REF: Planning Application 2025/62/93355/E  
Location : Land off Woodward Court, Mirfield WF14 0PY  
Type of Comment : OBJECTION

**1. Traffic and Road Safety issues the development will create/ worsen**

Image 2.3 Proposed Hepworth Lane Site Egress

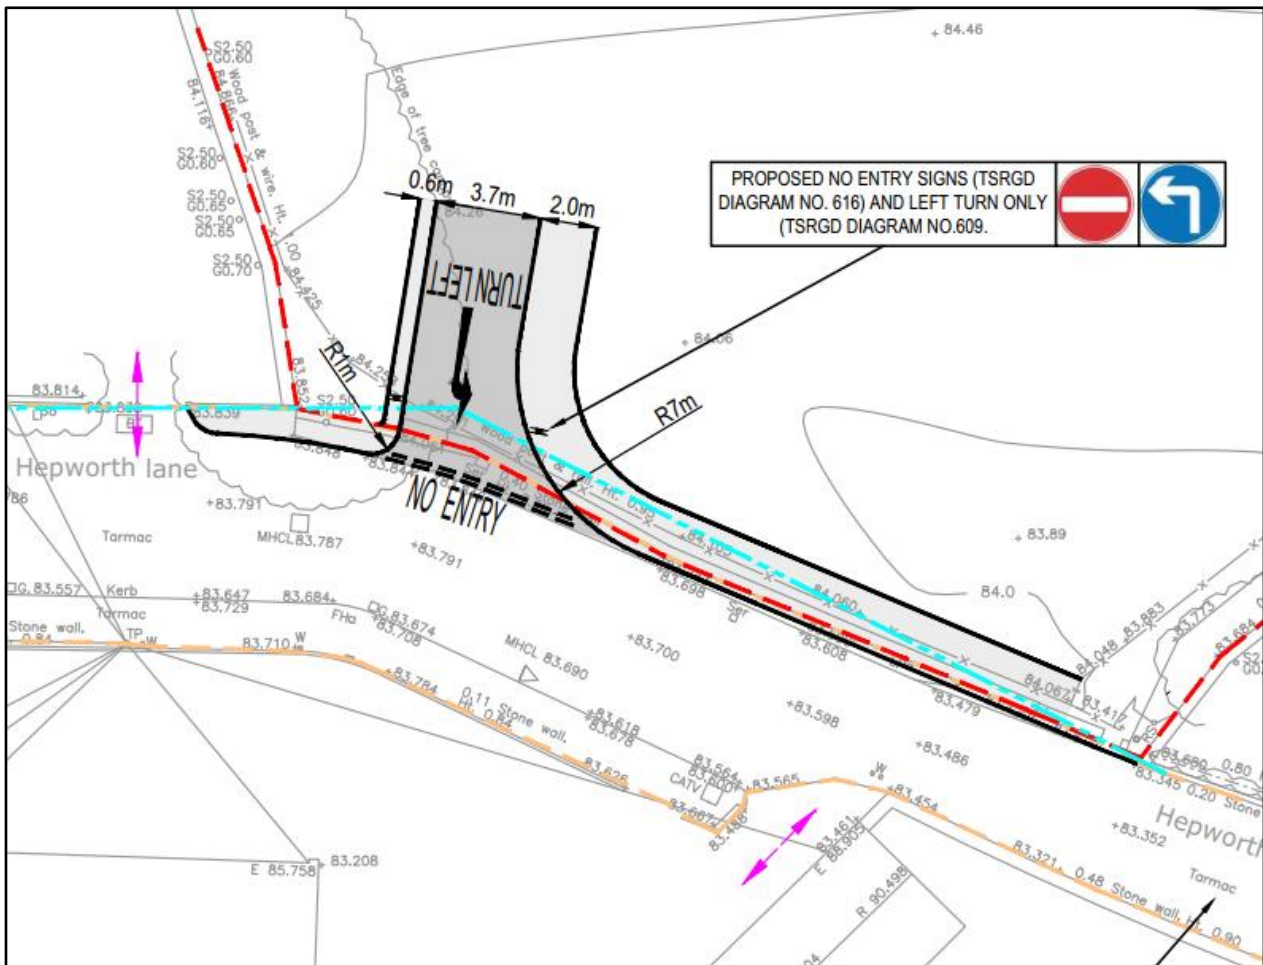
The proposed exit onto Hepworth lane is dangerous both for vehicles and pedestrians. The supporting information provided by the developer is insufficient, incorrect and does not create a true picture of the local area.

Directly where the vehicle is turning is where cars are usually parked and so this actually evidences that a larger vehicle such as a refuse truck or a fire engine would not have the ability to actually get out. This further image also illustrates that once you add parked cars to the road it is going to be very difficult for cars entering Hepworth lane, leaving Hepworth lane and exiting this new development as there simply is not room.
